KIRKLEES METROPOLITAN COUNCIL

STRATEGIC PLANNING COMMITTEE

Planning Application 2025/92713

Rear of 23 to 43 Moor Lane, Gomersal, Cleckheaton, BD19 4LF

Client PPJ Developments  
 Project 2539 : Moor Lane : Residential  
 Title Proposed Site and Section

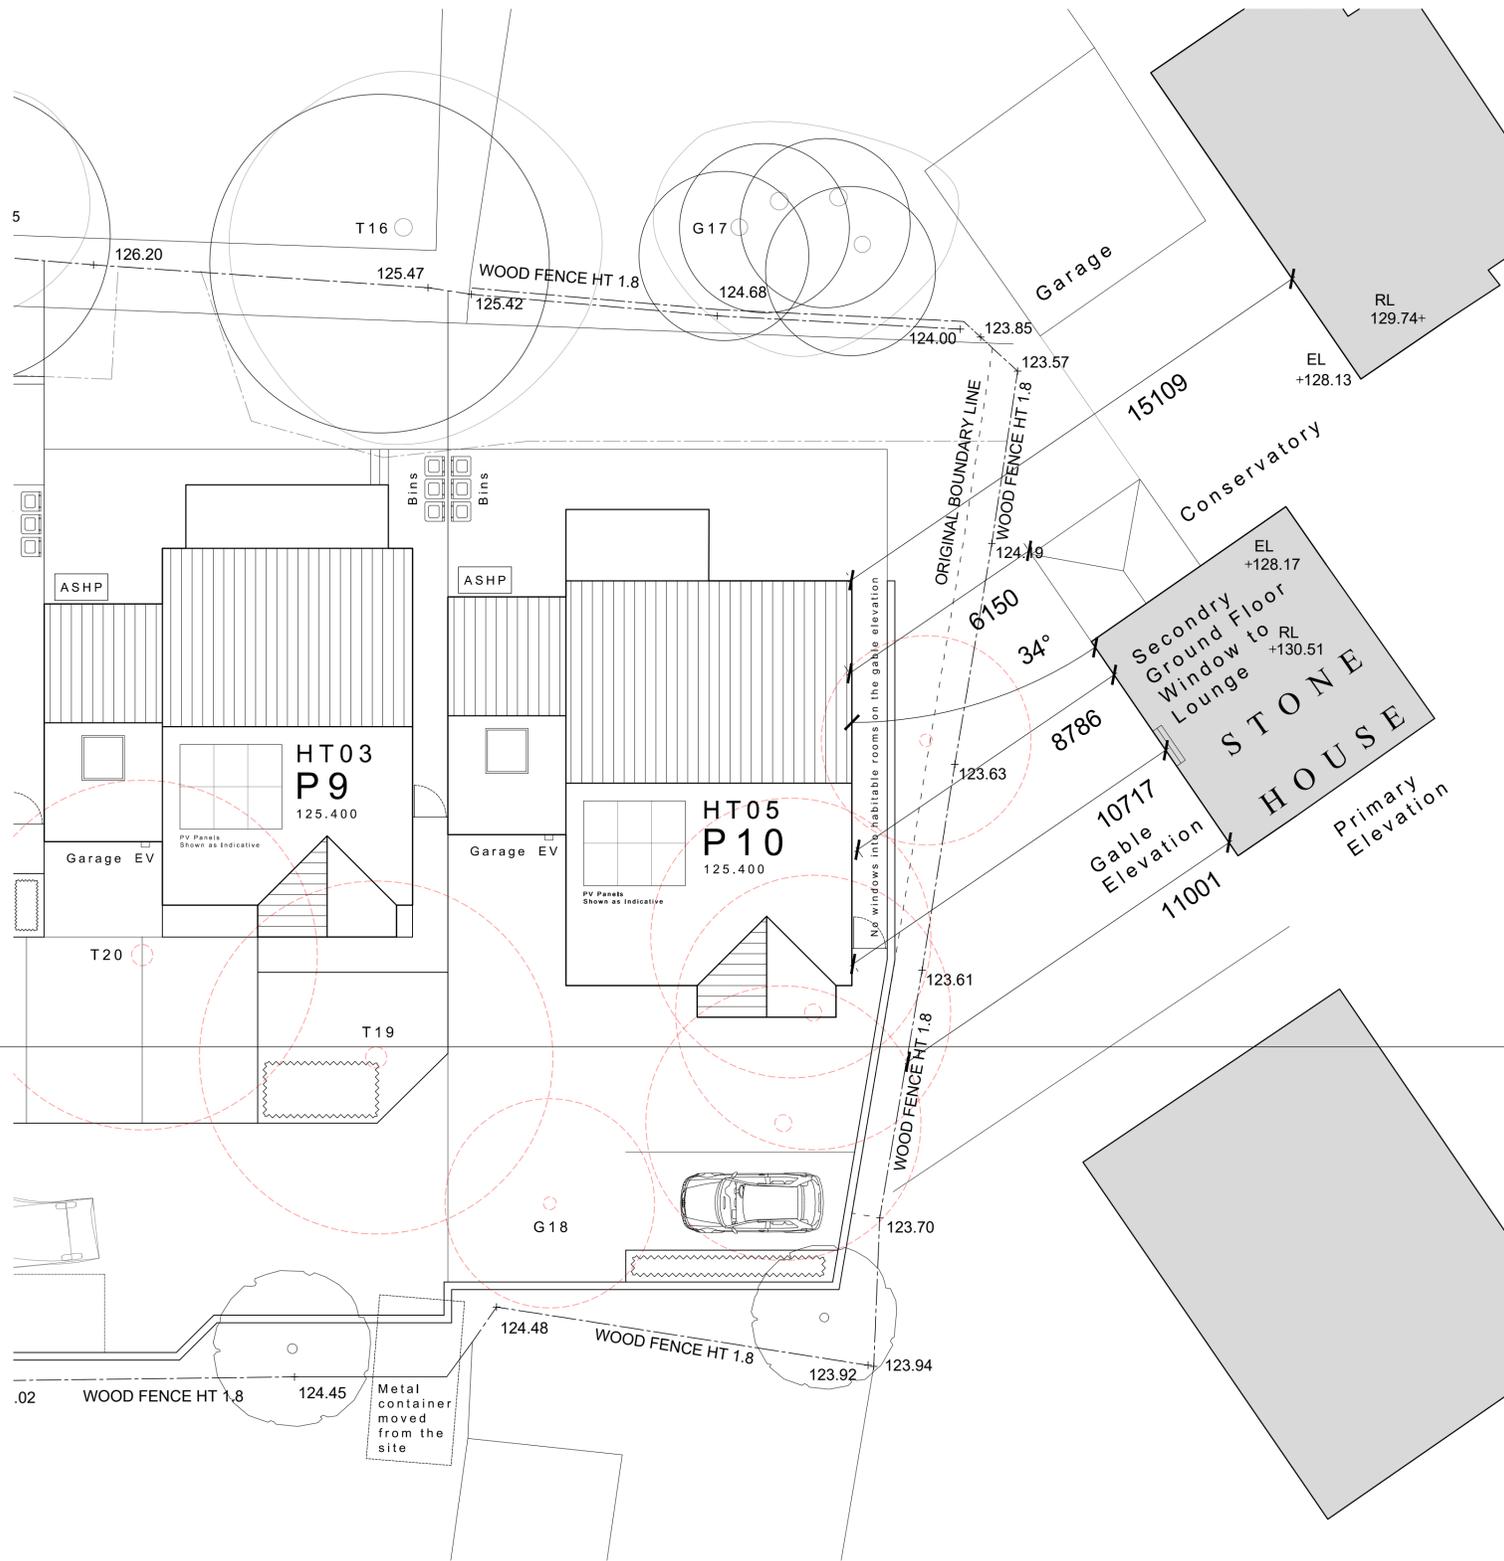
- Plot 1 which is still shown as a 3-storey house, and another 3-storey house is now planned for Plot 5. Whilst plot 5 maintains the eaves level at the top of the 1st floor windows (as are all the other houses), this has the 2nd floor within the roof space, with typical sloping ceilings and Velux style windows. Plot 1 will have the eaves level at approximately 1.00

metre above the 1st floor windows to allow for more traditional height rooms on the 2nd floor. Also, because the outside driveway level of plot 1 is approximately 1.35 metre lower than the level by the entrance door, this will add to the overall height of the house when viewed from the entrance to the site. This will impact even more on Peel House, the Grade 2 listed building, and also other adjacent properties.

Response: These matters are largely considered within the committee report. It is accepted there are different positions on whether the property is 'two-storey, with habitable rooms in the roof space', or 'three-storey'. Officers do not consider the property to be a 'true' three-storey property, although it is accepted that the eaves and overall height are higher than a typical two-storey property.

Regardless of whether it is considered two-storey or three-storey, officers have considered the impacts of the building as proposed, in terms of its scale and appearance, based on the submitted plans. As set out within the report, officers are of the view the building's appearance and scale are acceptable, having regard to land levels, the historic environment, residential amenity, and all other material planning considerations.
